# Planning Services Sign Permit Review Form

Date of Submittal	Application Number	Applicant	Landowner
11/02/2023	SIGN2311-0001	Elite Custom Signs	HMD Development Inc.

Reviewed By:	Date of Review	Review Results
Sarah Arbour	11/15/2023	<input type="checkbox"/> Approved <input checked="" type="checkbox"/> Denied  <input type="checkbox"/> More information needed

**PHYCINITY/CHANNEL LETTERS**  
**OVERVIEW\_OPTION B**

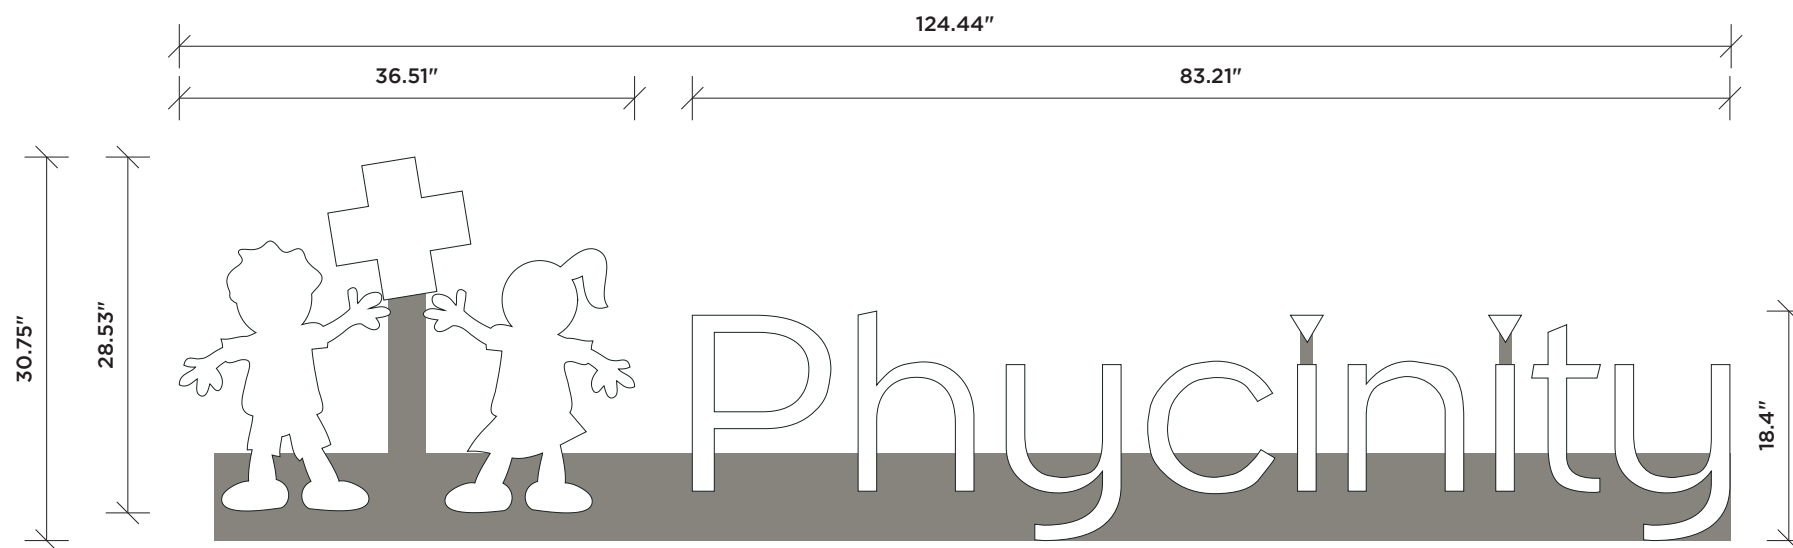
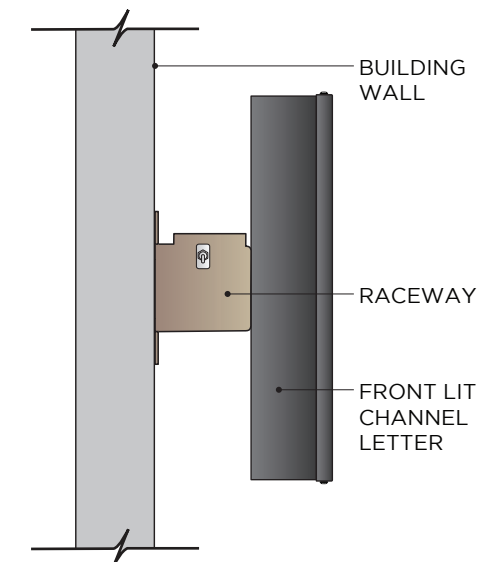
Comments
1. The proposed sign is too large. The maximum permitted signage for this location is 23.8 square feet and currently 26.44 square feet is proposed.
